## Chapter V - Section 55 Subdivision Summary Form

Copper Chase at Sterling Ranch

# V\_1 Sub Sum review.pdf Markup Summary 6-28-2023

FINAL PLAT  
COPPER CHASE AT STERLING RANCH  
FILING NO. 1  
JOB NO. 09-014  
DATE PREPARED: 04/27/2023  
DATE REVISED: 07/14/2023

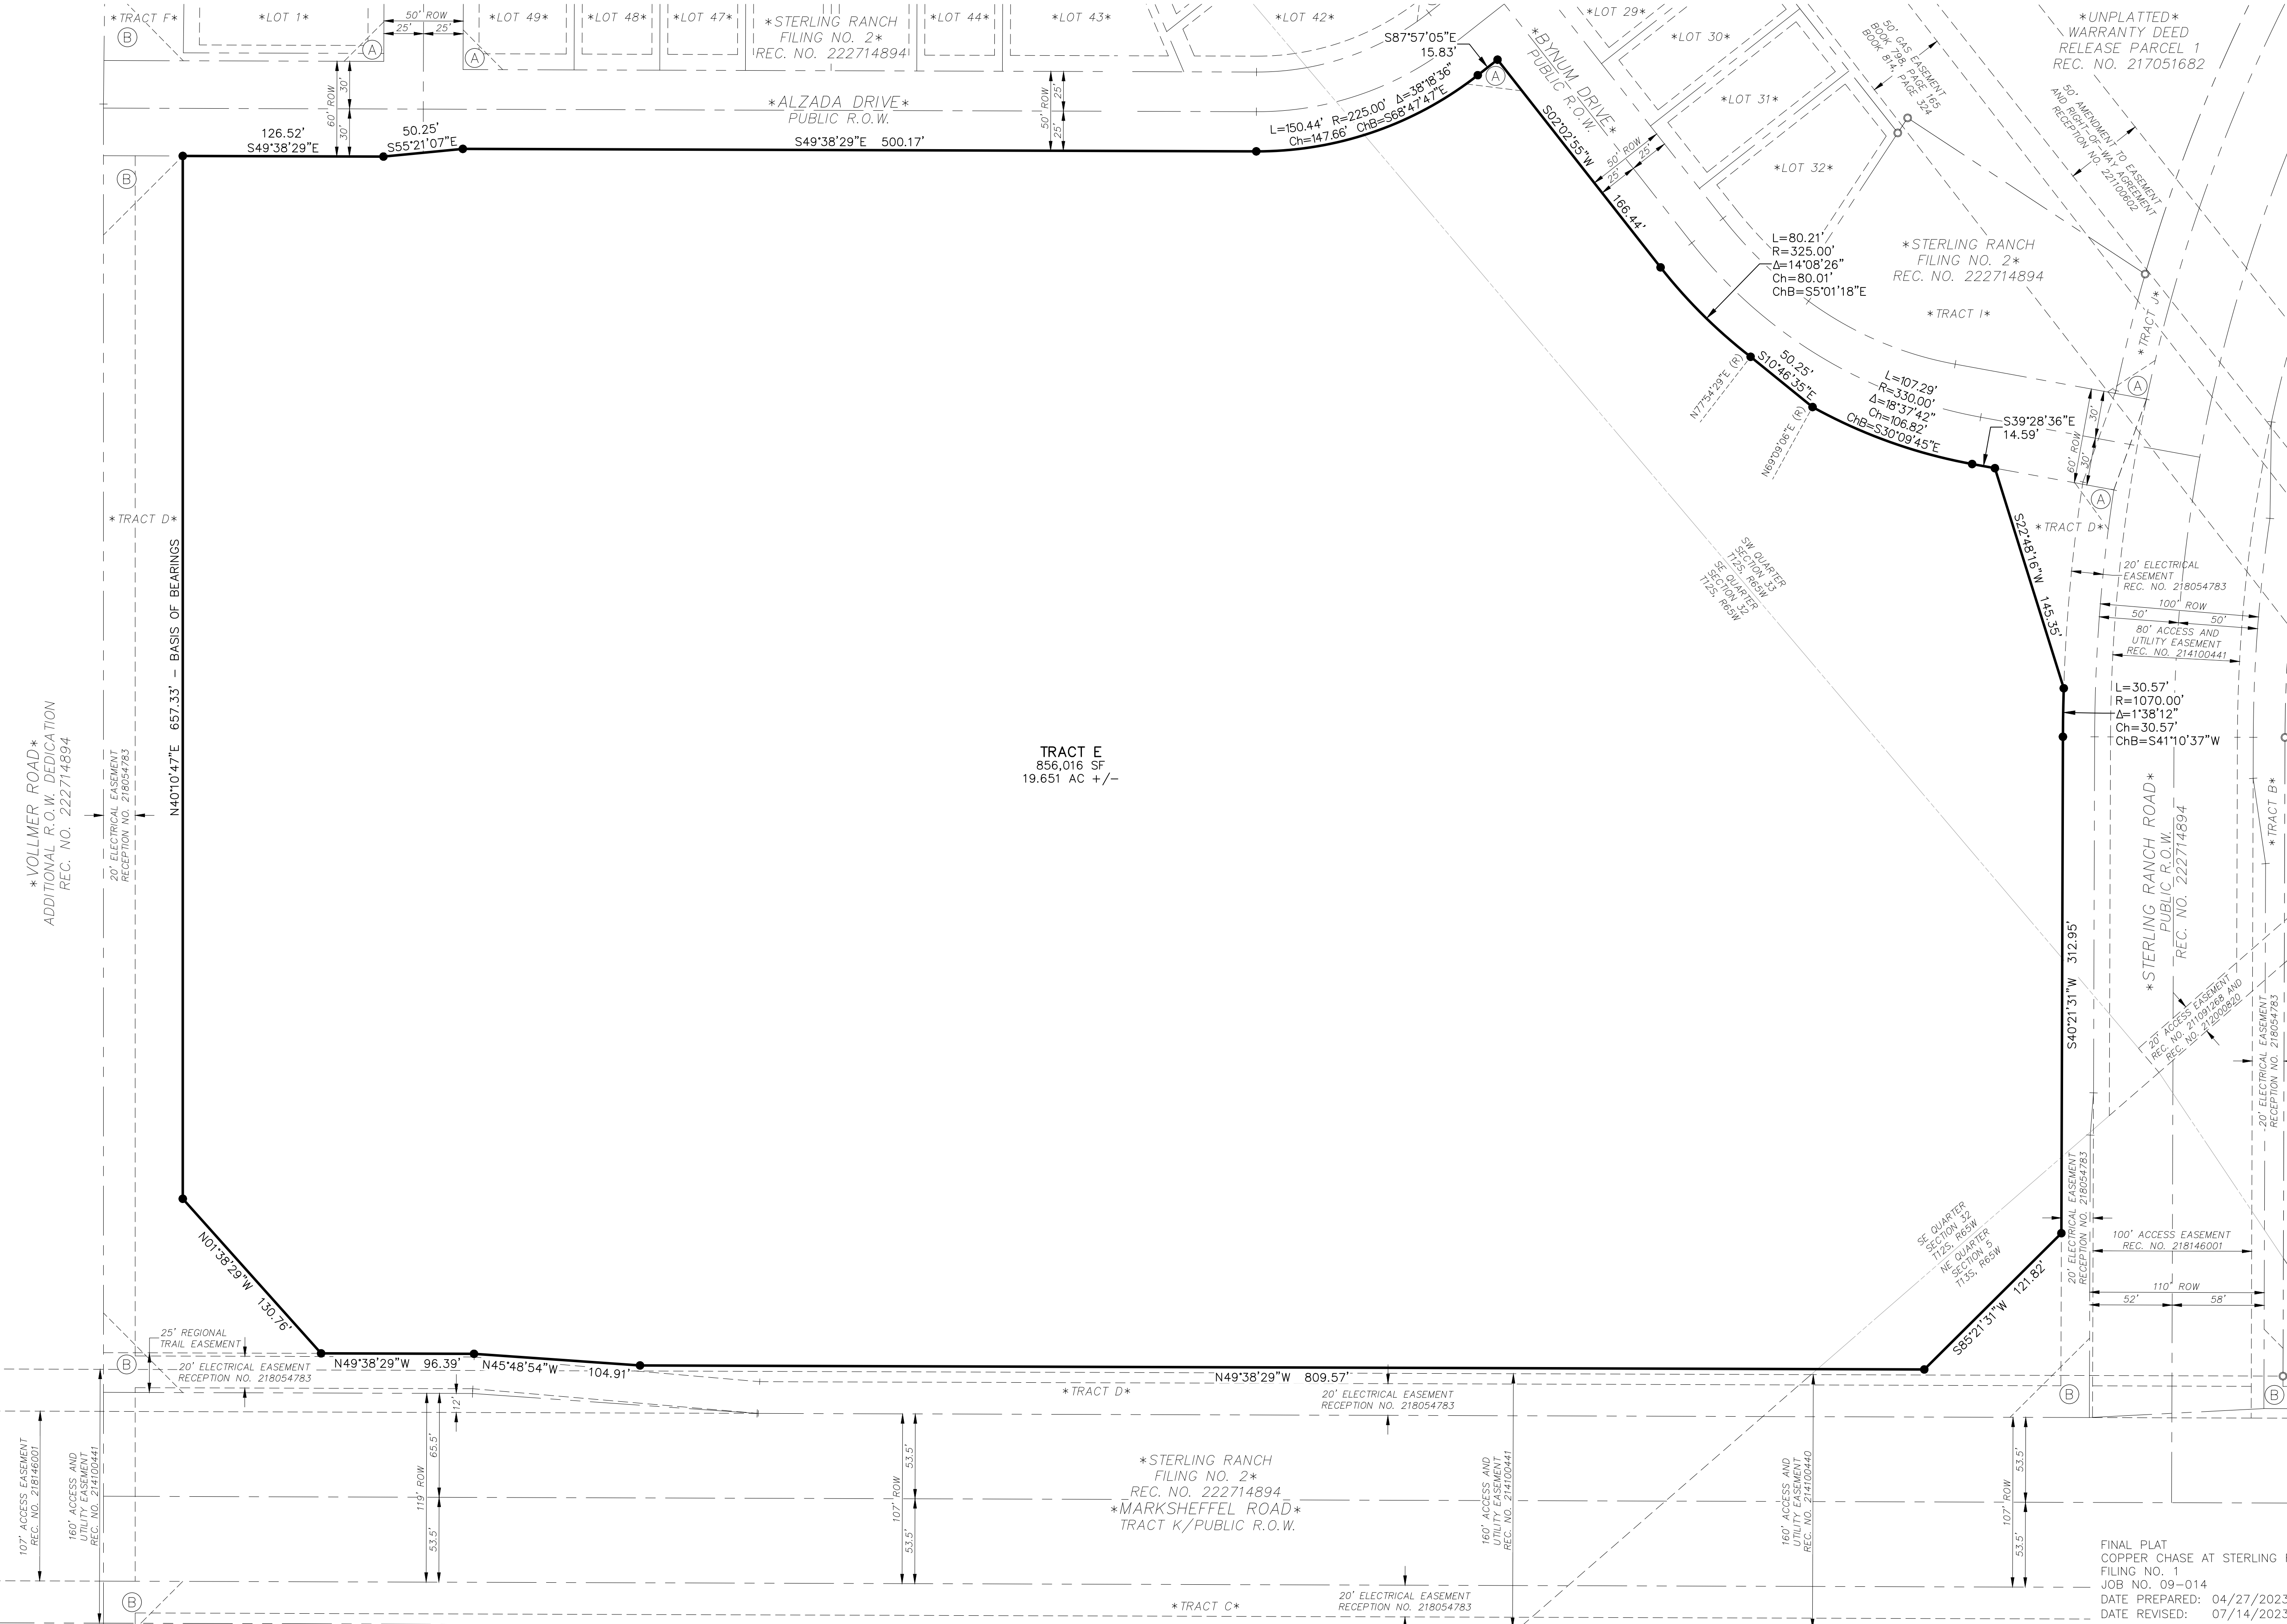
Areas and % do not match with what is shown on plat cover sheet. Please revise so both documents match.

Areas and % do not match with what is shown on plat cover sheet. Please revise so both documents match.

UPDATED
